City of Albuquerque Stormwater Construction Site Inspection Report

Project Name:	Puerta Del Bosque				
Location:	Campbell & Rio Grande				
Site Contact Name & Agency	Steve Hernandez - Sivage steve@dmcnm.com	ESC File No.	G12E035		
		NPDES Id. No.	NMR10013N		
Inspection Date:	09/09/19	Start/End Time:	1010/1015hrs		
CoA Stormwater Inspector:	Timothy E. Sims				
Construction Phase:	Home construction				
Type of Inspection:	<input checked="" type="checkbox"/> Regular	<input type="checkbox"/> Storm Event	<input type="checkbox"/> Post Storm Event >0.25"	<input type="checkbox"/> 311/Complaint	<input type="checkbox"/> Follow Up

Concrete Washout Area

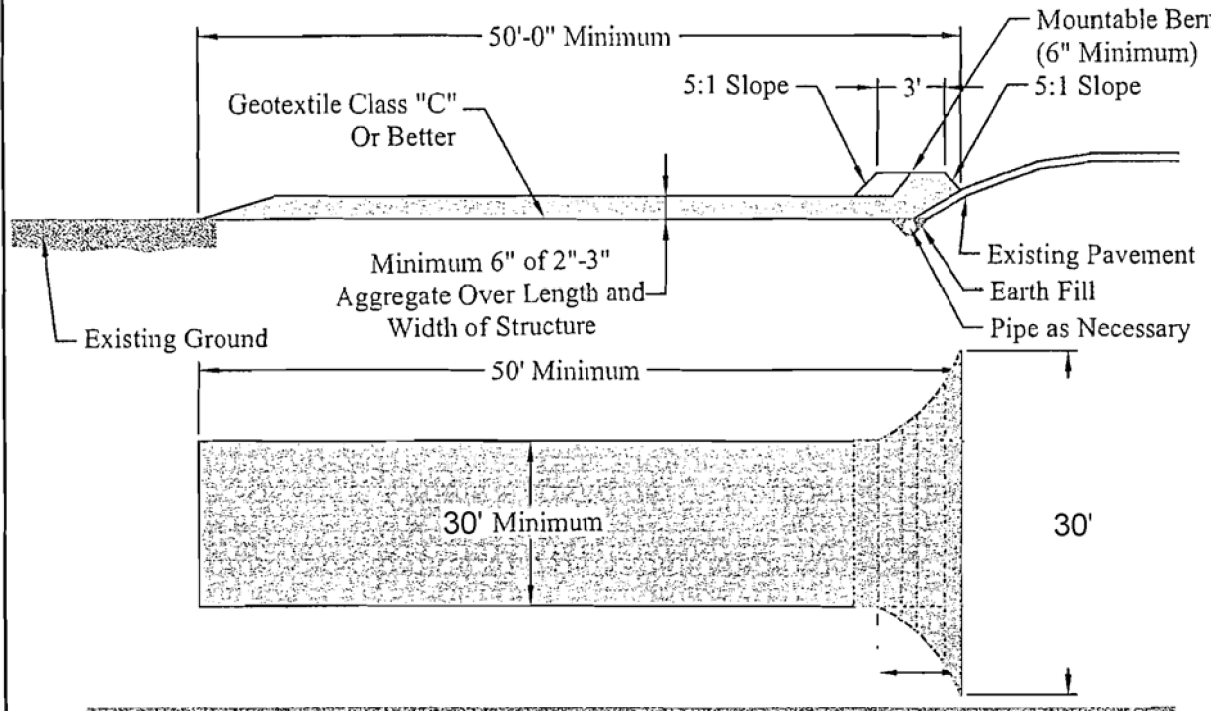
Item Number	Deficiency/ Corrective Action		
	no issues observed		
	Please provide latest SWPPP self-inspection report.		
	***Concrete washout facility will require maintenance soon also the facility on lot 1. Please ensure trades continue using provided washout facilities.		
2.1	Discharge off site? (Y/N)	No	
4	Self Inspection Reports	requested	Latest report Date: 7/24/2019
